**Subject: Meadowlake Airport Expansion 1041 Permit Application, Review #2 (AASI-18-001)**

The Planning Division of the Community Services Department has reviewed the Meadowlake Airport Expansion 1041 Permit application, Review #2, and has the following comments on behalf of El Paso County Parks.

ISSUE RECORD		AIRPORT LAYOUT PLAN - FUTURE	SHEET NO. 04 of 21
DESCRIPTION			
		CDAG GRANT NO. 2014-FLY-01	VIATION PROJ. NO. 2014.FLY.01
		DATE: MAY 2019

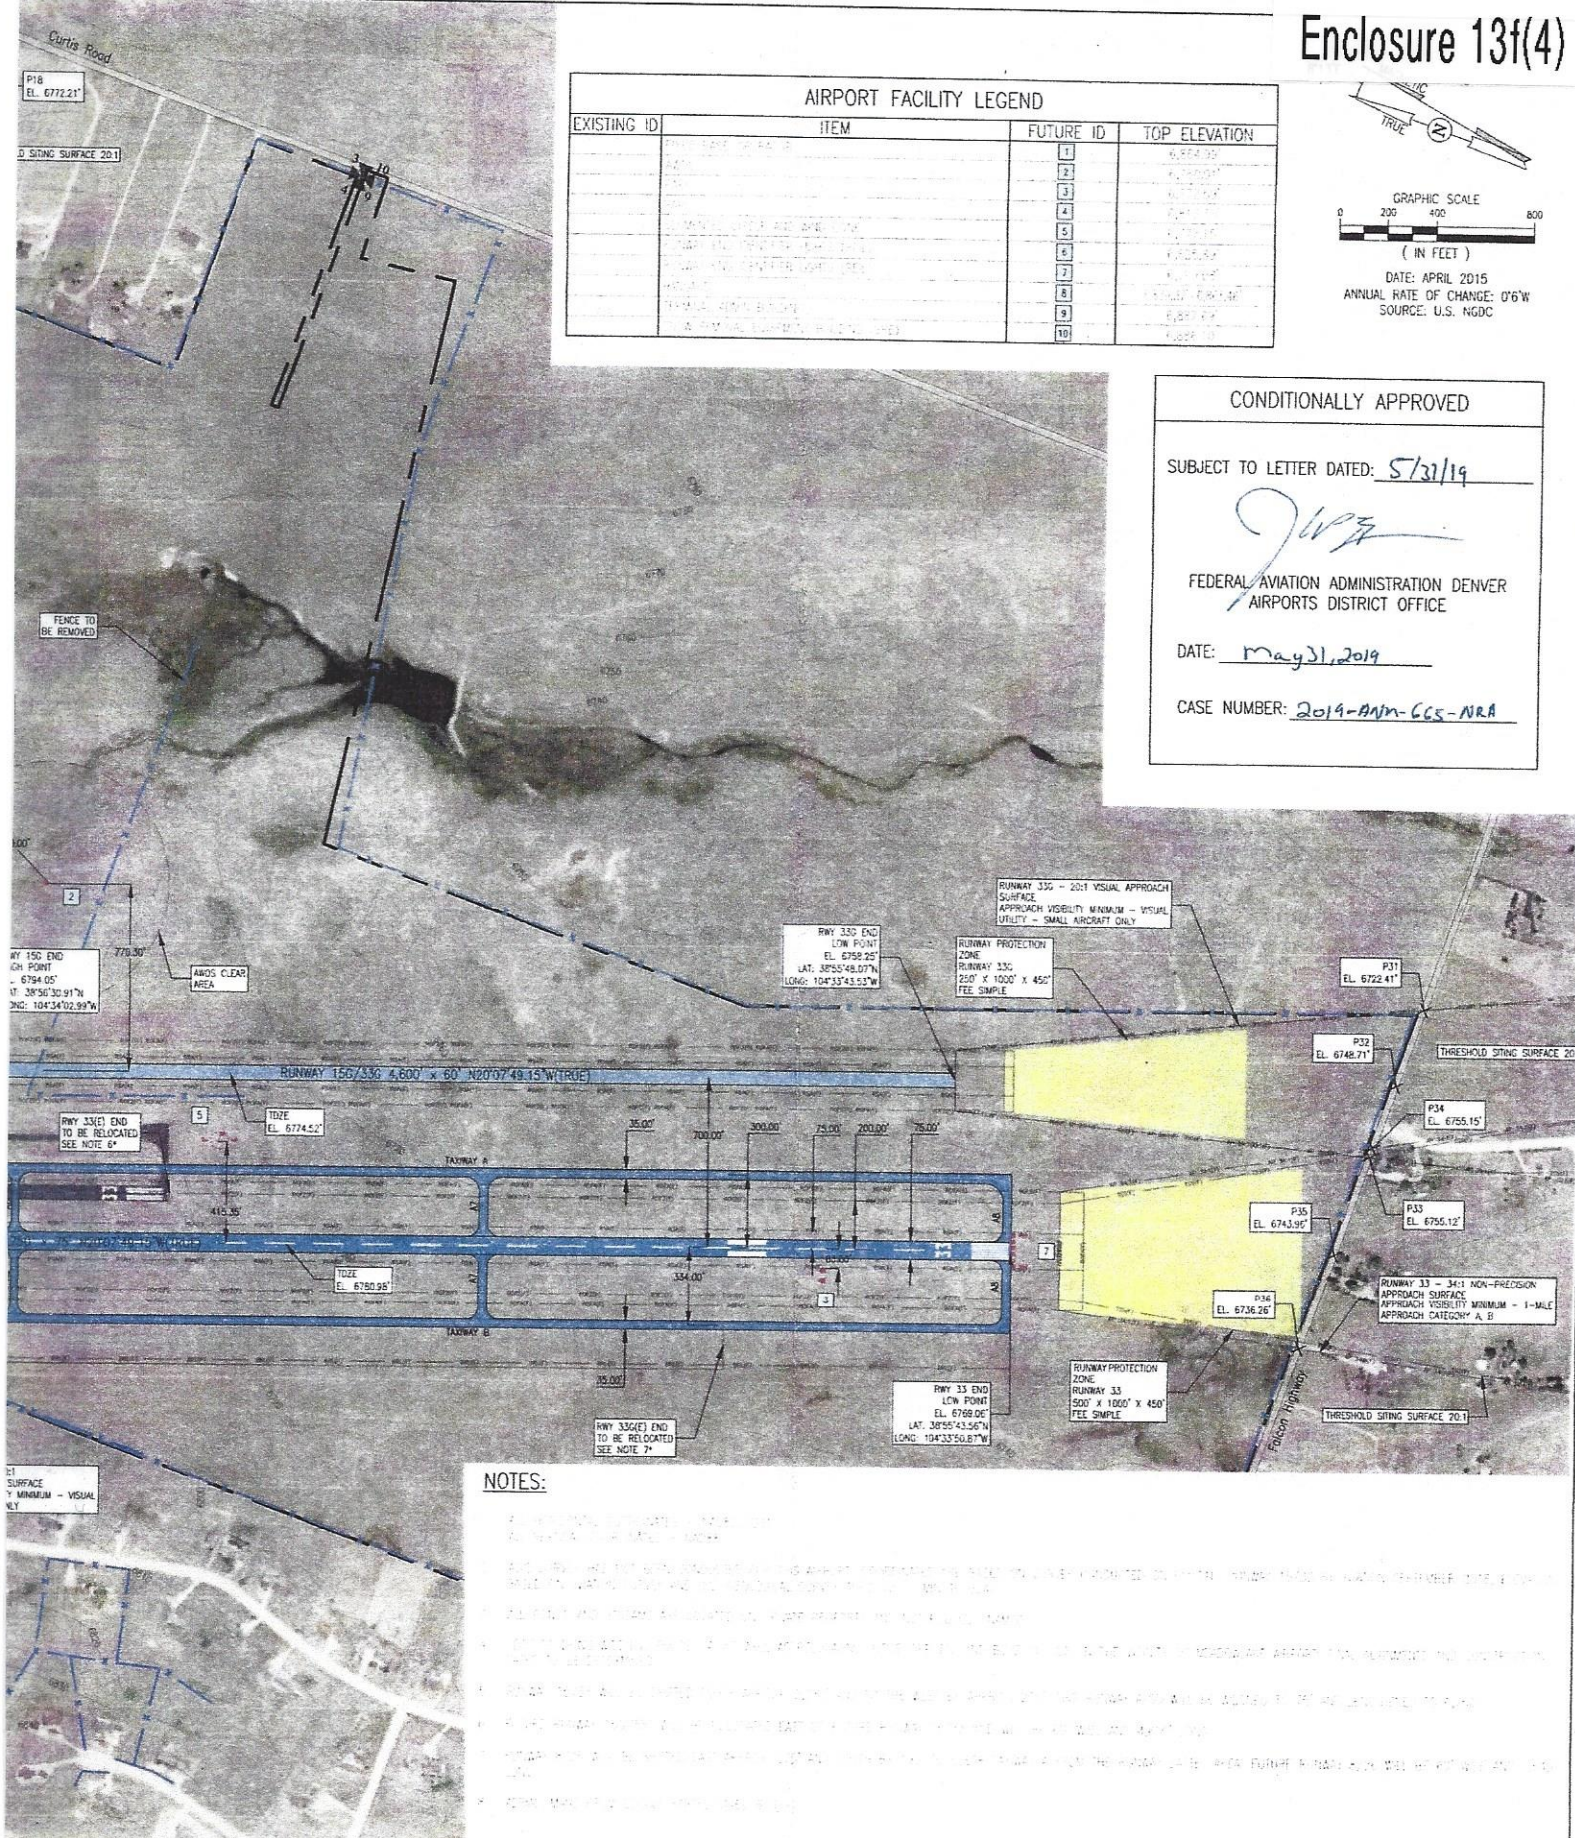
Furthermore, the Parks Master Plan also shows the Judge Orr Secondary Regional Trail running through the airport property, crossing one of the Master Planned asphalt runways. This proposed trail alignment is not conducive to the runway expansion recommendations of the Meadowlake Airport Master Plan, and due to the secure nature of the airport property and overall concerns for public safety, this particular trail alignment, and therefore all subsequent trail easements, will not be pursued. The Judge Orr Trail will most likely continue along Judge Orr Road and turn south on Curtis Road as a means to bypass the airport property.
